Rezoning Transportation Analysis

Petition Number: 2020-057

General Location Identifier: Tax ID 11303105A

Date	Description
05-18-20	First Review

Schematic Site Plan Rezoning Petition #2020-xxx

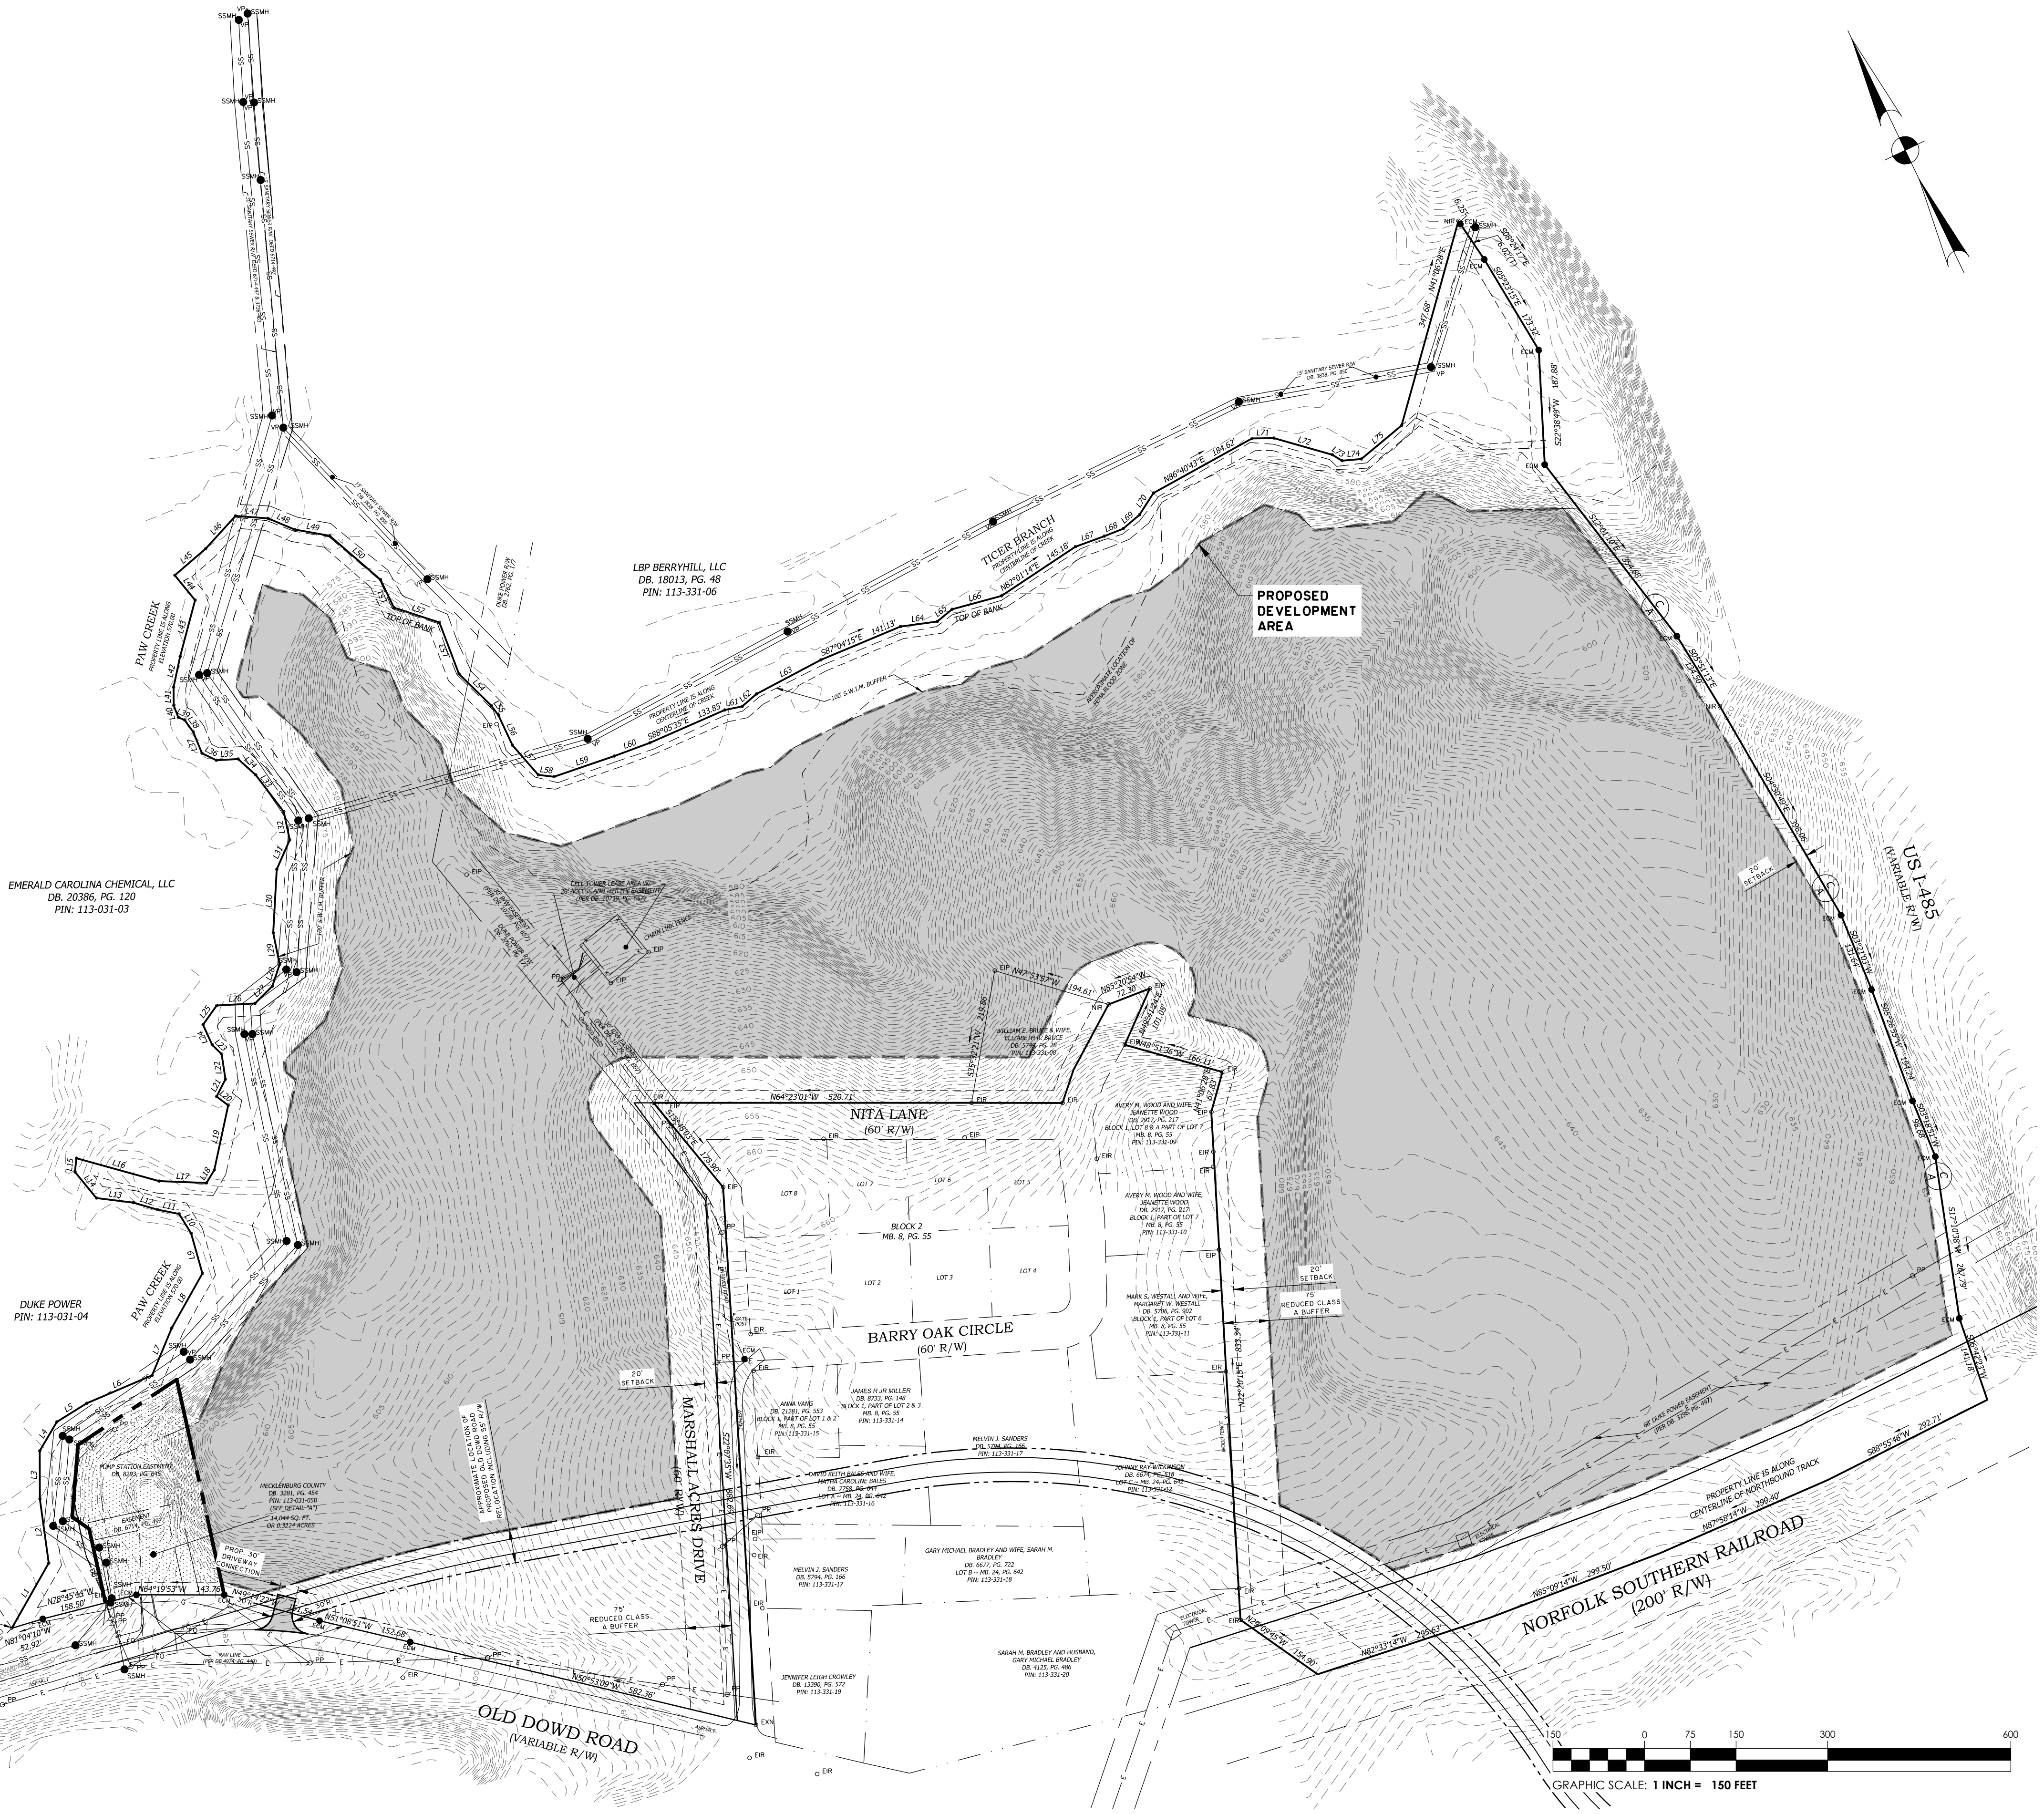
The site is located on a minor thoroughfare road. The petitioner should revise the site plan to meet the ordinance requirements and the outstanding items listed below.

- Traffic Study** A Traffic Impact Study is not necessary for the complete review of this petition.
- In accordance with the Charlotte Regional Transportation Planning Organization (CRTPO)'s Thoroughfare Plan, the petitioner should revise the site plan and conditional note(s) to commit to dedicate a minimum of 100-feet of right-of-way (future major thoroughfare) from the road centerline for the realignment of Old Dowd Road. The site plan should label and dimension the right-of-way from the road centerline. **CDOT to confirm the future Old Dowd Rd Realignment cross section.**
- The petitioner should revise the site plan and conditional note(s) to construct right and left-turn lanes at the proposed access on existing Old Dowd Road. An internal 3-lane section should also be designed to accommodate the future realignment of Old Dowd Road.

- The petitioner should revise the site plan and conditional note(s) to commit to construct an 8-foot minimum planting strip, and 6-foot sidewalk on existing Old Dowd Road per Chapter 19 of the City Code. The site plan should label and dimension both items from the edge-of-pavement/shoulder and road centerline.

5. The petitioner should revise the site plan and conditional note(s) to commit to construct an overland connector along the future Paw Creek Greenway on existing Old Dowd Road to meet the City of Charlotte BIKES Policy and Greenway Master Plan.

6. The petitioner should revise the site plan and conditional note(s) to confirm whether the proposed development will consist of one or two buildings, to determine applicability of the Subdivision Ordinance.

7. The petitioner should revise the site plan to add a note specifying dedication and fee simple conveyance of all rights of way to the City before the site's first building certificate of occupancy is issued. CDOT requests right of way set at 2' behind back of sidewalk where feasible.

8. The petitioner should revise the site plan to add a note specifying all transportation improvements will be approved and constructed before the site's first building certificate of occupancy is issued. The petitioner may phase transportation improvements if said improvements and phasing are explicitly described in site plan notes.
